Letter of Intent for Special Use Permit

Re: Application for Special Use Permit – Accessory Metal Building (40' x 80' x 16') on 4.77-Acre Parcel, Zoned RR-5.

Property Address: 625 Slocum Road, Colorado Springs, CO 80830

Tax Schedule/Parcel Number: 4412003003

Project: Equipment Storage
Special Use: Rural Occ-Outside Storage
Owner:Pineda David Morales
Parcel:4412003003
Lot 1, Blk 4 Toy Ranches Sub 1
Zoning: RR-5

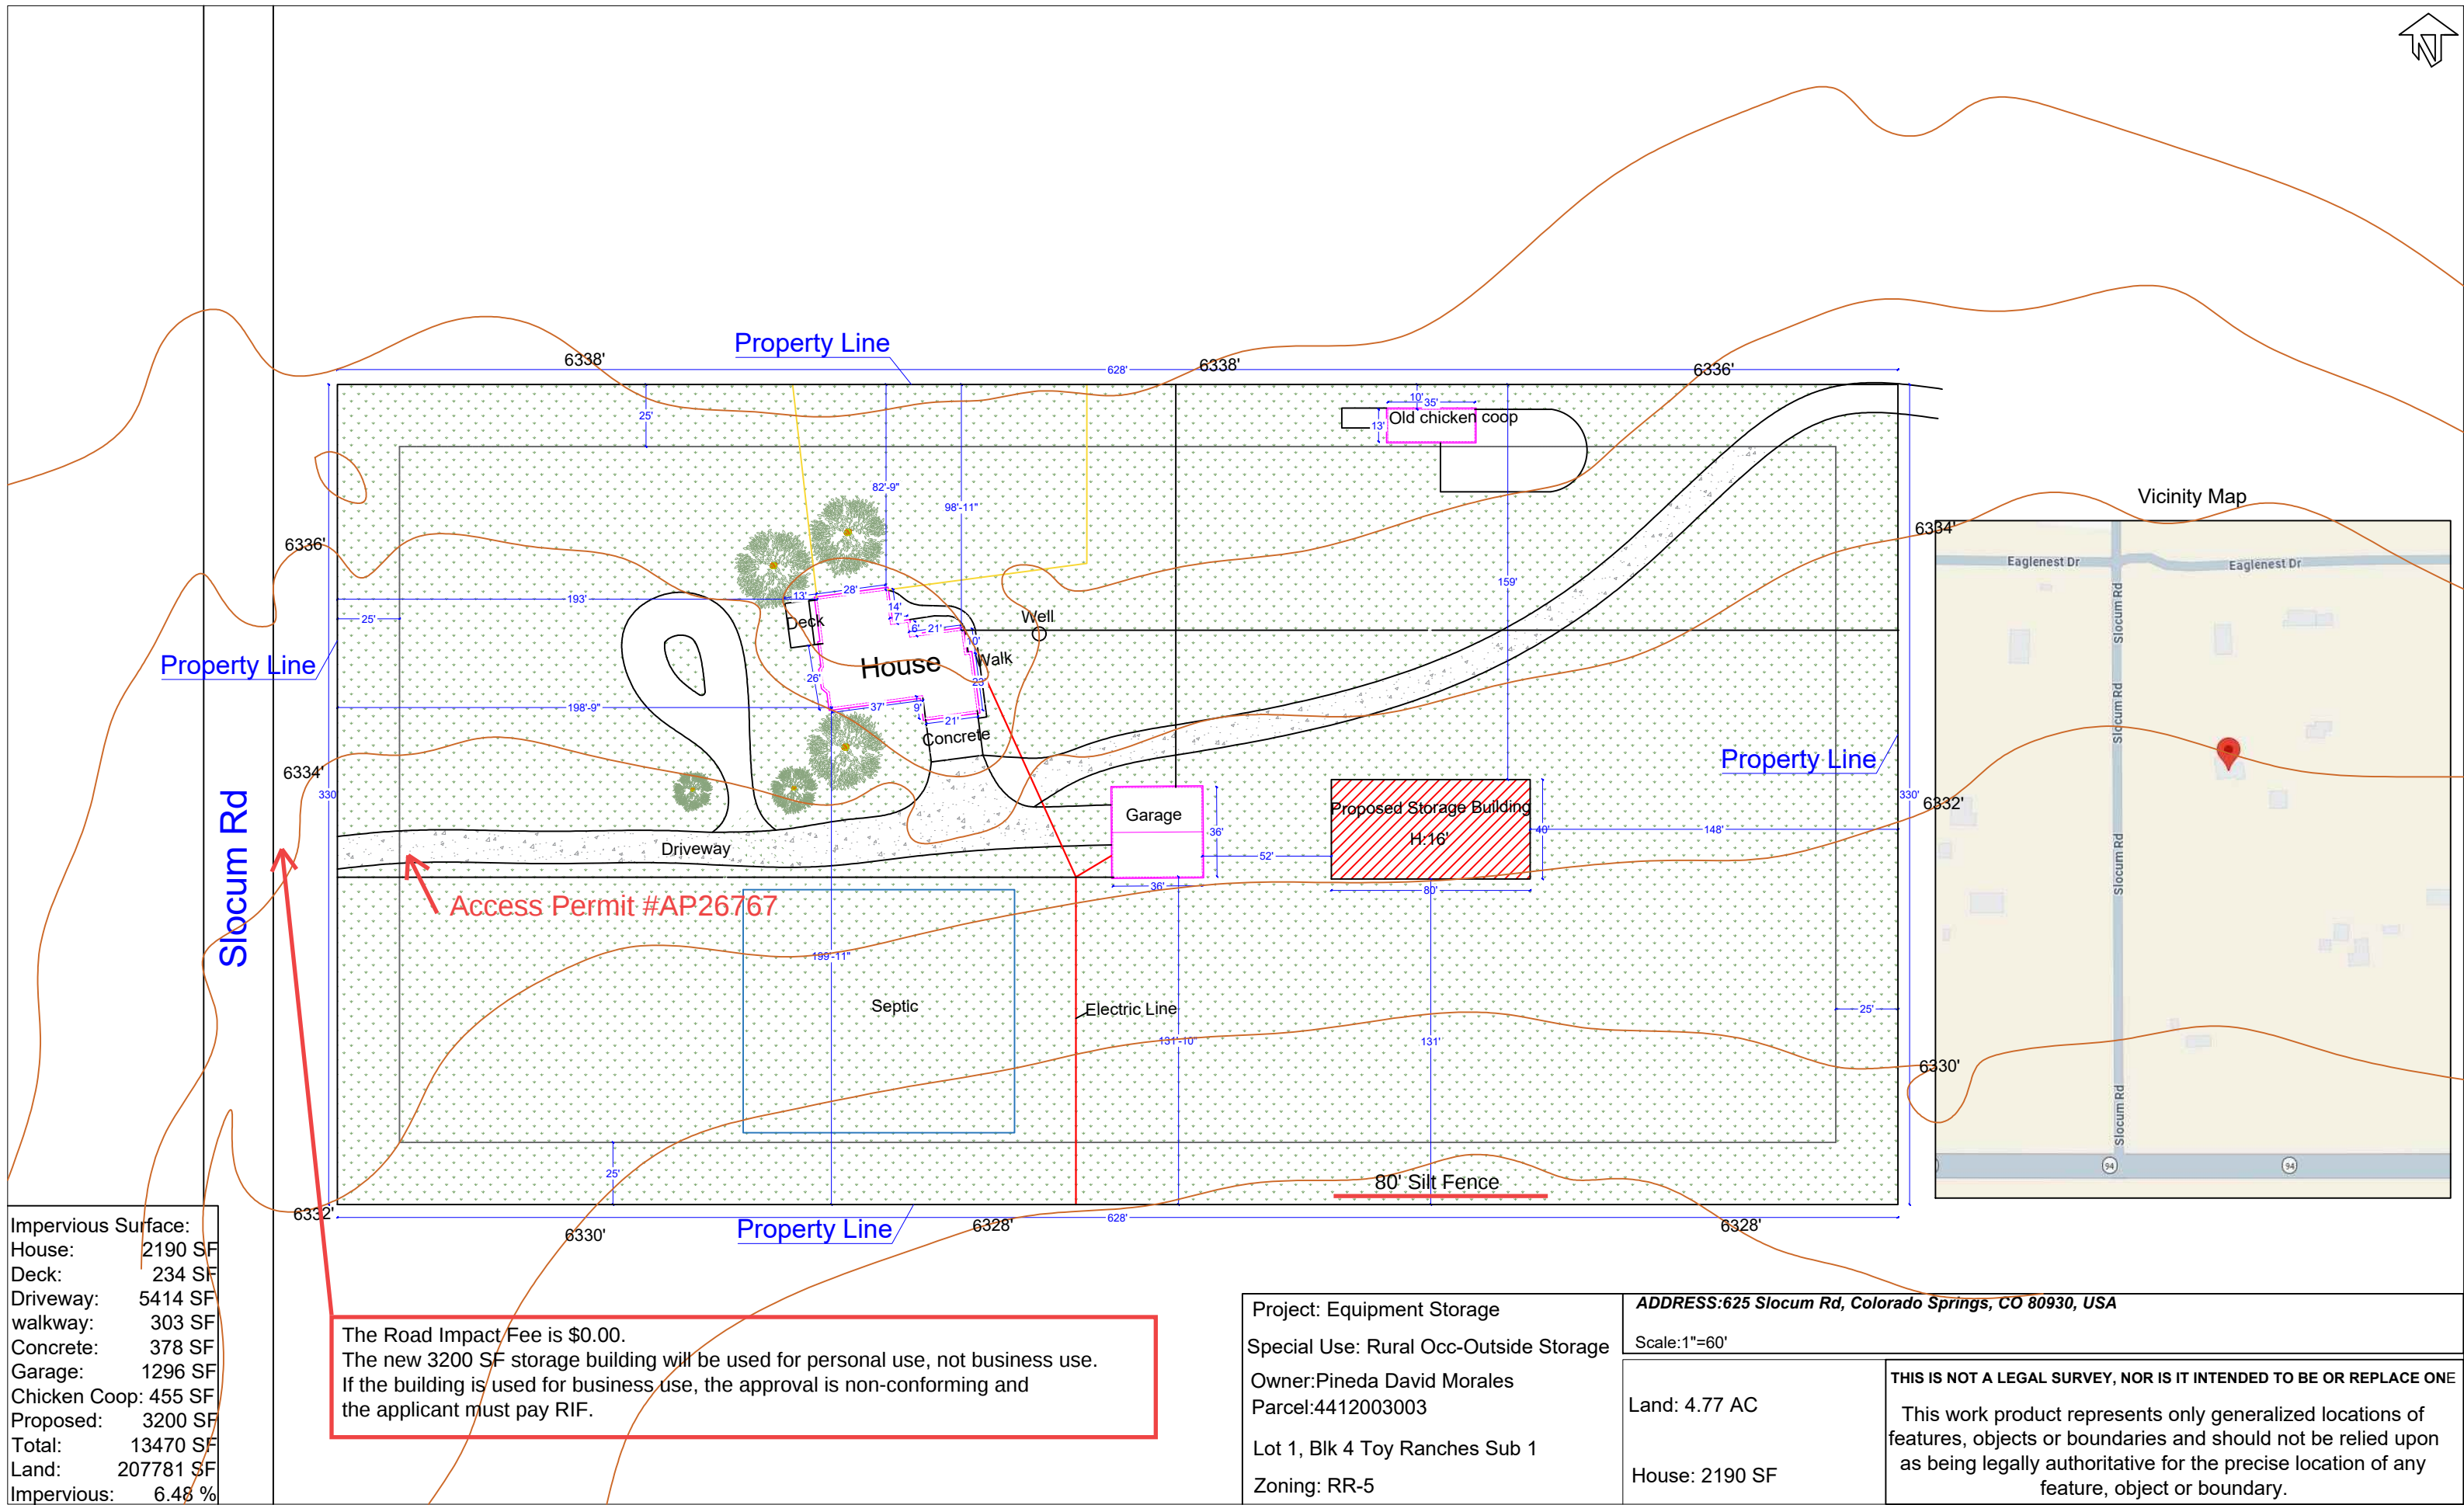
is there landscaping or no?

is there lighting or no?
